**Consultation Response from KC,
Trees**

2022/93699 4-8, School Hill, South Crosland, Huddersfield, HD4 7BY

Demolition of existing two-storey rear extension, erection of two-storey rear extension and alterations to form habitable dwelling (Listed Building within a Conservation Area)

RETAINING WALL
Scale 1:20

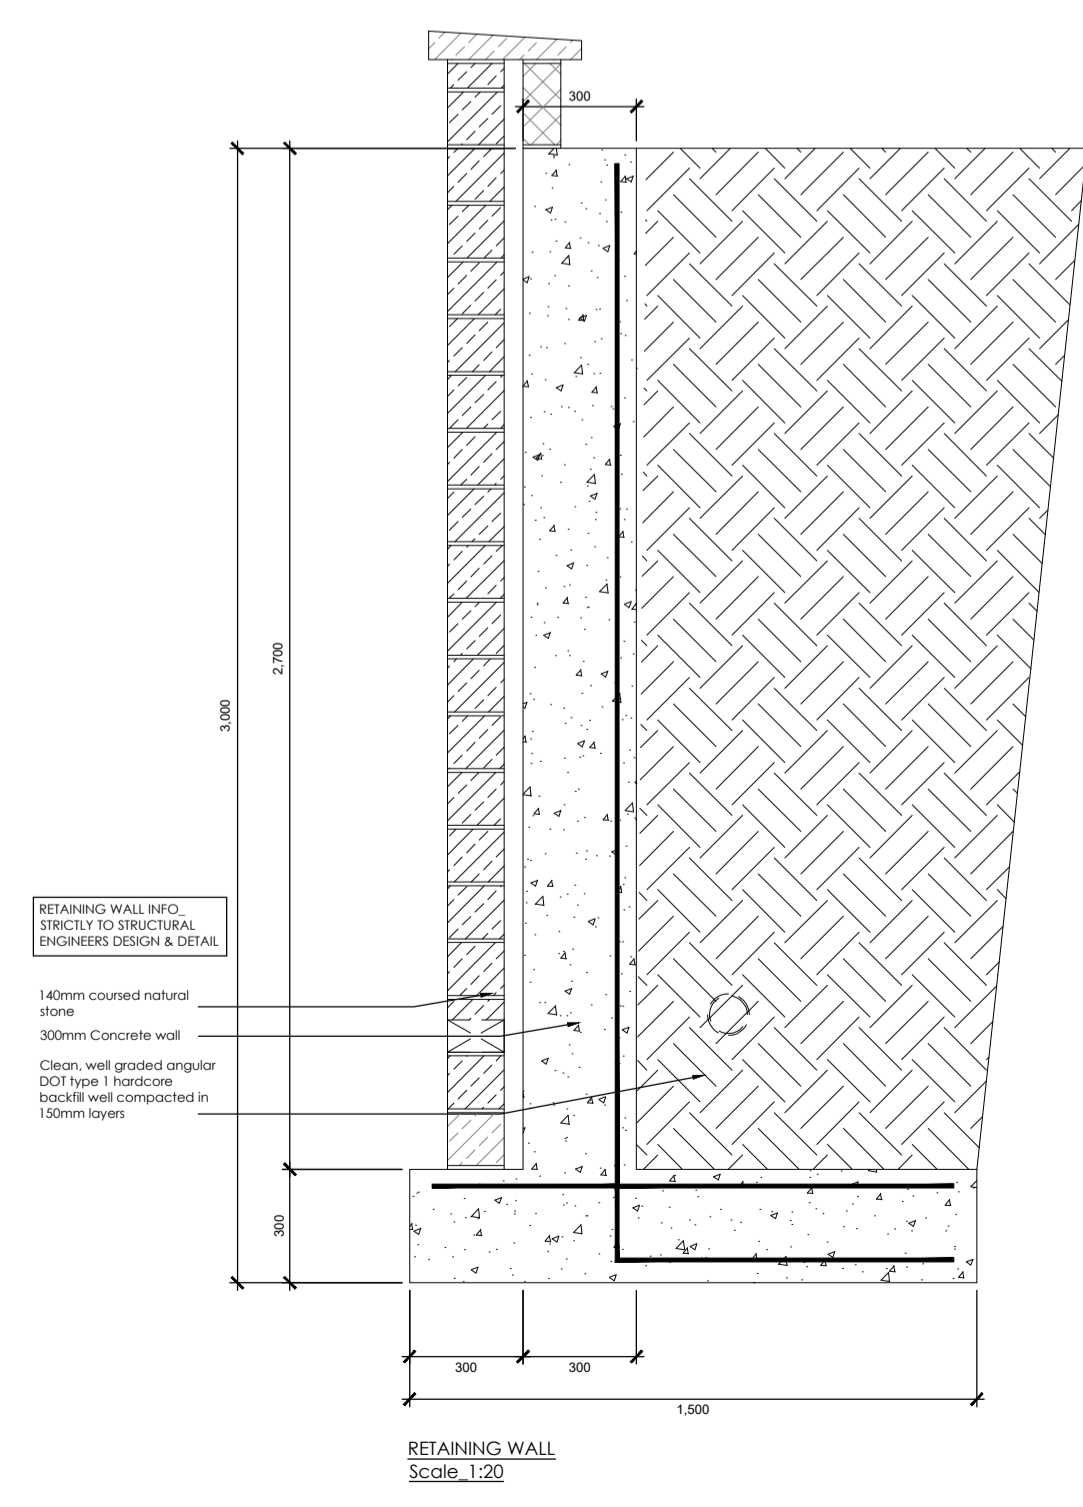
Following on from previous comments I do not have any objection to the rear extension proposal as there should be no detrimental impact to the trees to the rear of the dwelling however, the unexpected excavation and loss of rooting area to the side of the property needs to be rectified.

I recommend a tree survey in accordance with BS5837:2012 to be undertaken in order to calculate the minimum root protection area of sufficient soil volume needed to be restored to maintain the viability of the adjacent trees as recommended in the standard.

This calculation will allow the position of any retaining structure to be determined, prioritising suitable soil type and structure to promote unrestricted root growth within the RPA and ensuring any necessary compacted backfill is outside of the rooting area.
